Memo

From Environmental Noise Solutions Limited

Subject Proposed bar at land to the rear of 2 Blacker Road, Mapplewell

Date 27 May 2026

Figure 4.1: Location of Glazed Areas

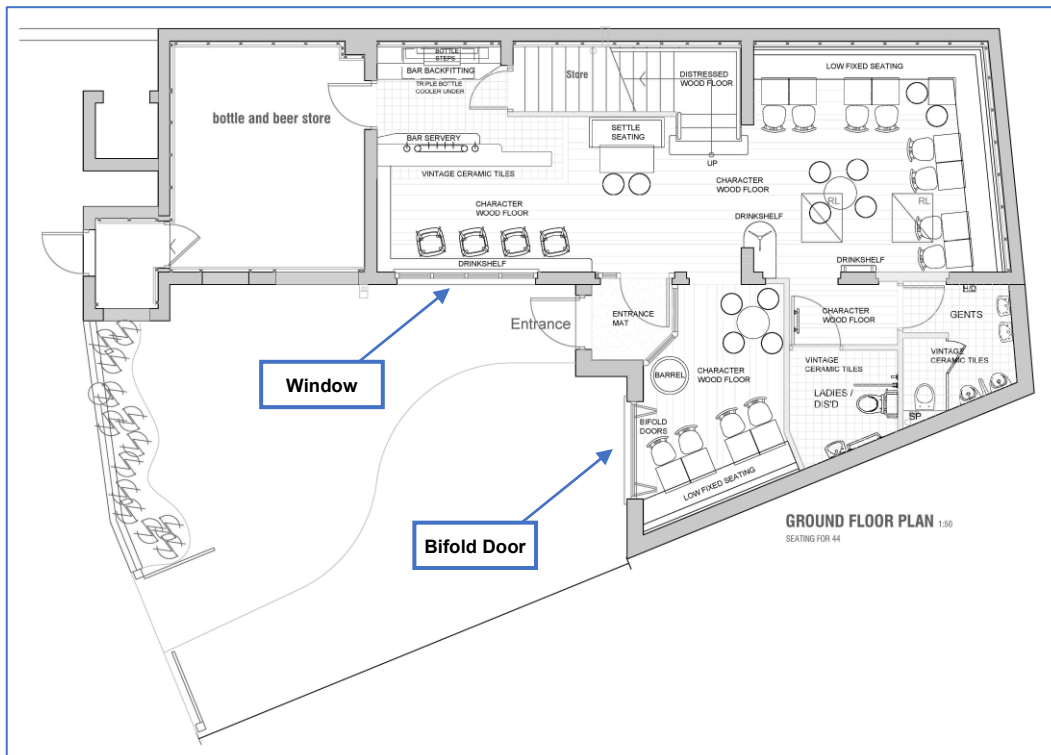
10 *“It is assumed that standard thermal double glazing (with a sound reduction performance of circa 28dB R_{w+Ctr}) has been installed” – as the glazing is already in situ, this should have been checked, not assumed.*

The music noise assessment focuses on the noise impact with the bifold door open (therefore offering no noise reduction) and so the precise sound reduction of any glazing at the site has no bearing on the assessment.

Further, standard thermal double glazing (i.e. 4 mm glass / 12 mm cavity / 4 mm glass) is the minimum possible glazing which would have feasibly been installed at the site in terms of noise reduction. Any other specification would offer higher noise reduction.

Figure 4.2: Location of External Speakers

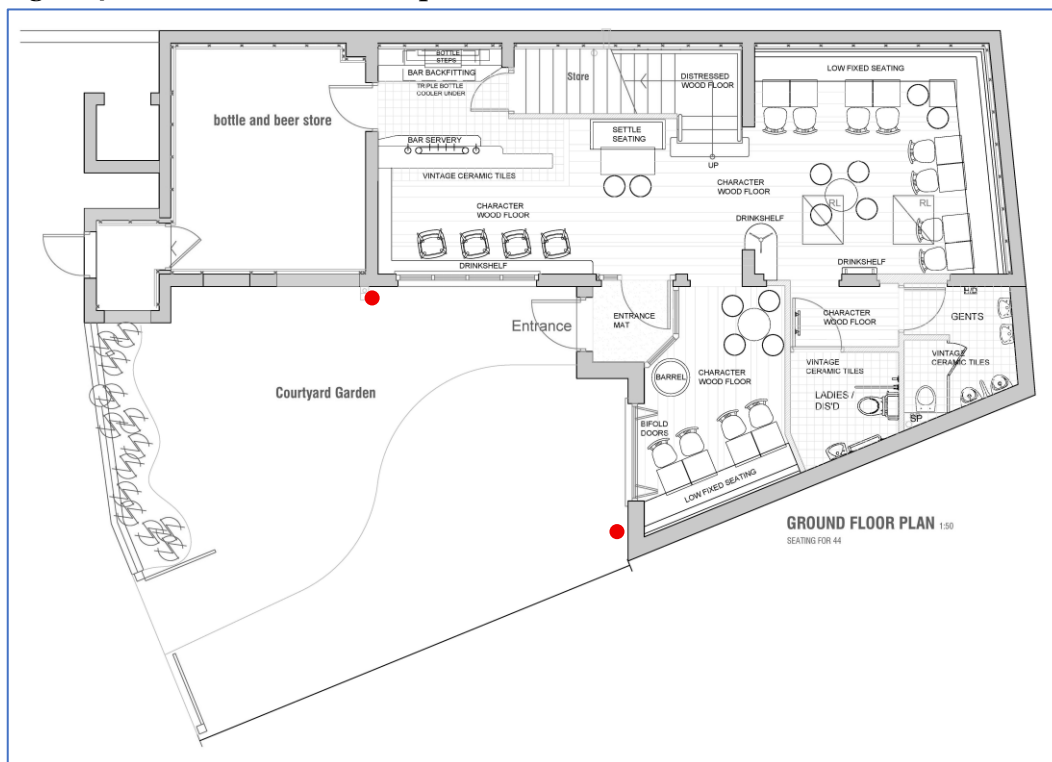
7 “to assess the potential for external amplified music, further measurements of the external speakers were taken...with the speakers set at the required level (amplifier volume dial set at 9 o’clock)” – Does “external amplified music” mean recorded music only? What is a 9 o’clock setting? Need more precise detail. What measures are in place to ensure the volume dial cannot be changed/increased from “9 o’clock”?

8 “noise levels were measured circa 62dB LAeq (15min) at 1 metre” – 62dB LAeq would generally be considered as background level (allowing conversations to be heard without the need to raise voices). Is this the applicant’s intention, to have background music only outside?

9 Does the “external amplified music” relate to recorded music, via the 2 existing speakers only?

To clarify, “external amplified music” refers to recorded music only played through an auxiliary cord to an amplifier connected to the external speakers.

The amplifier itself does not have numbered volume controls, hence the reference to 9 o’clock as shown below.

The operator has advised that the amplifier volume is never varied from the 9 o’clock position and only staff will have access to the amplifier meaning that it cannot be increased by third parties. However, if concerns remain about external amplified music, then it is considered that a limiting noise level of **62 dB(A) at 1 metre from the speaker** can be set as part of an appropriately worded planning condition.

Appendix 2 – Approximate Noise Measurement Position

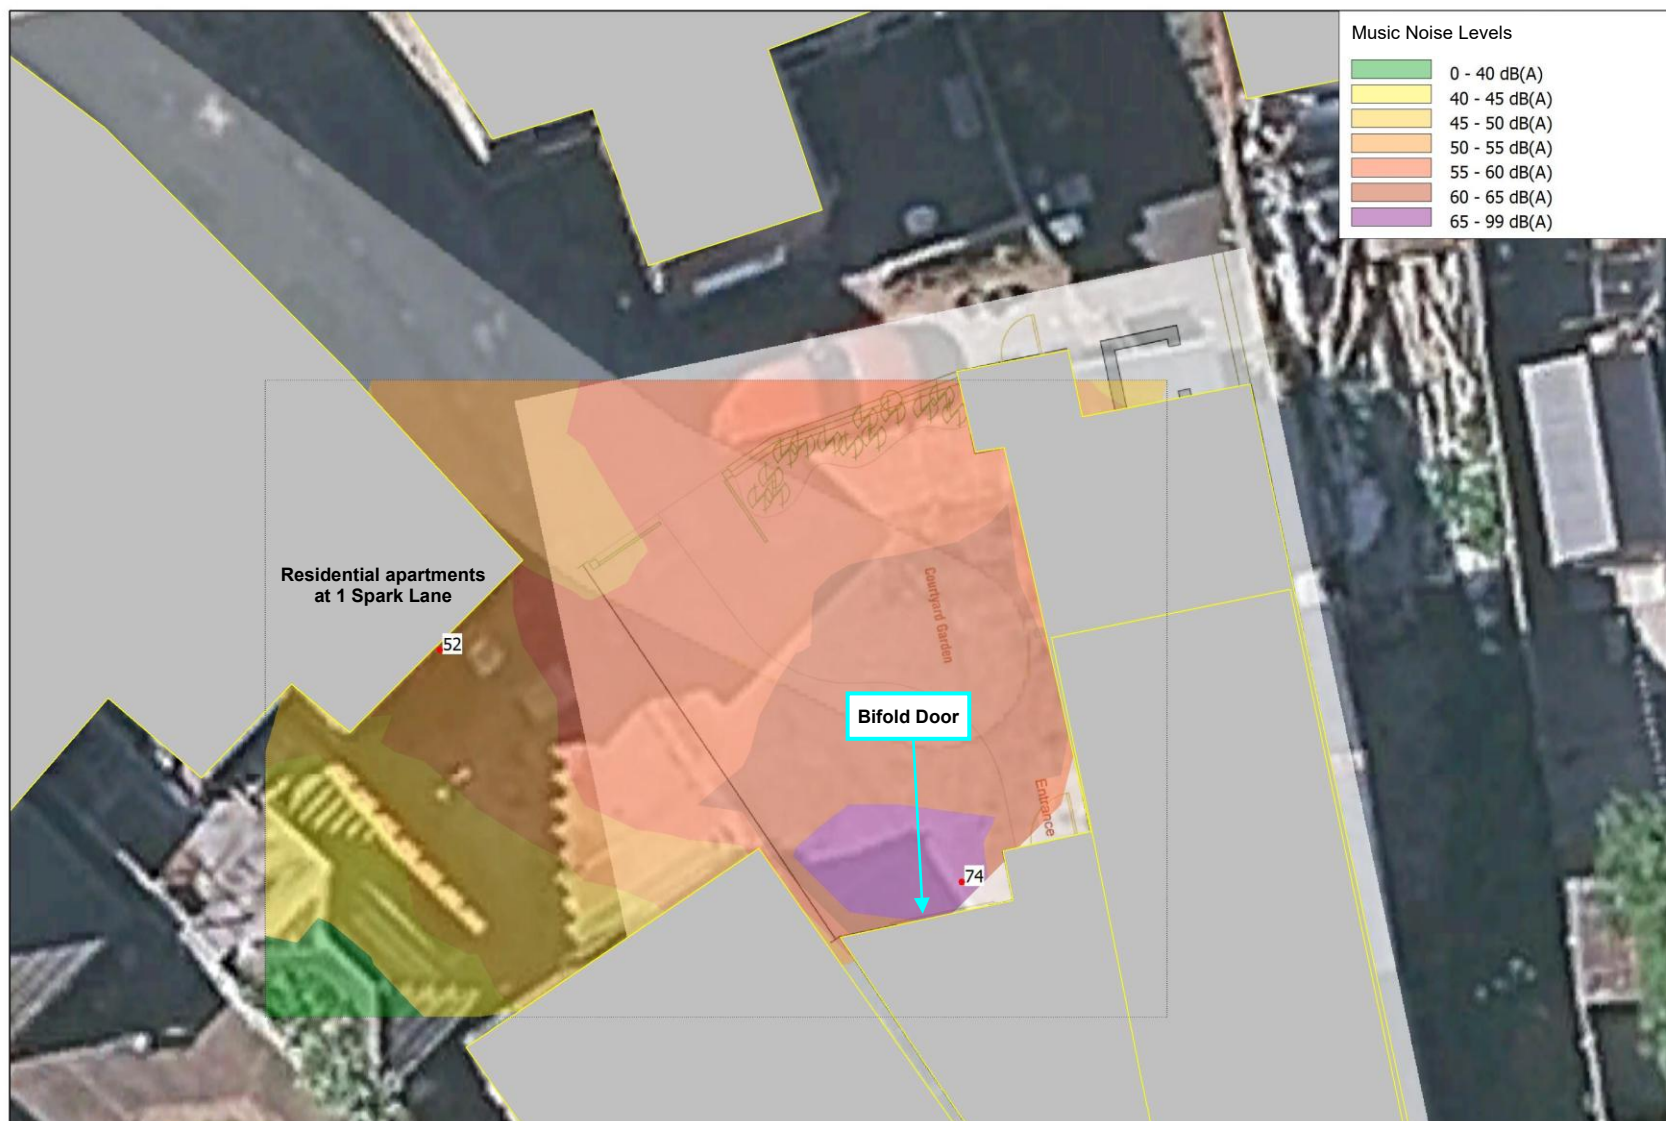
2. Measurements were taken on days when existing noise levels would be expected to be generally higher, rather than measured on the “worst case scenario” days such as Wednesdays and Thursdays. The lowest background measurement should be used, rather than an average.

3. Patron noise from the premises is not considered to be part of the existing noise environment. In addition, there is no detail regarding the number of people present at the time of measurement. The measurements taken which include patron noise should not be included in any existing/background noise data sets or calculations.

The background noise level used for the assessment of music noise at the premises is taken from Sunday evening data on an evening with no events at the bar and no patrons using the external area. Background noise levels (the steady, underlying noise level) were not therefore impacted by noise associated with the premises on Sunday.

In the absence of noise associated with the premises itself, Sunday evening is considered worst-case as there is typically less residual noise (i.e. traffic) than on weekdays.
